REF: 3/2020/1063 RIBBLE VIEW FARM, ALSTON LANE, PR3 3BN

Further to our email correspondence, we wish the following comments to be taken into consideration when determining the above application for change of use for Doggy Day Care Centre services.

Figure 1: Location Plan & Measurement Position

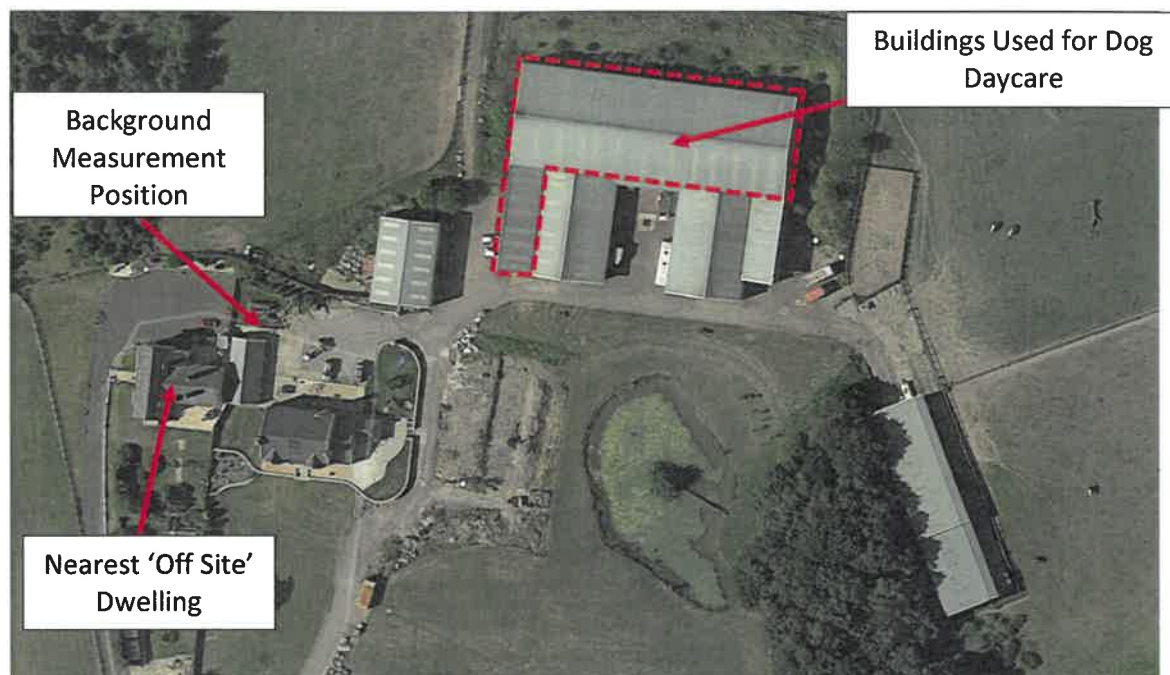
The noise report prepared by Martec, in 2.0 Site Design, sets out that the nearest “off site” property will control the overall impact of the development. We highly dispute this assumption that is dismissive of the impact of noise and that as a minimum Significant Observed Adverse Effect Levels should be anticipated with the likelihood being Noticeable and Disruptive Levels affecting other nearby properties.

Furthermore, all the focus of the application has been on the dogs being exercised solely in the arena and conveniently overlooks the inclusion of an external dog run to be wrapped around the north and east sides of the arena building. This run is a new built feature that has no construction/sound proofing detail and was ignored within the Martec report. The external run has also been overlooked/omitted from the Design Statement which states under Site and Location on page 1 that "No changes to the external face of the building will take place".
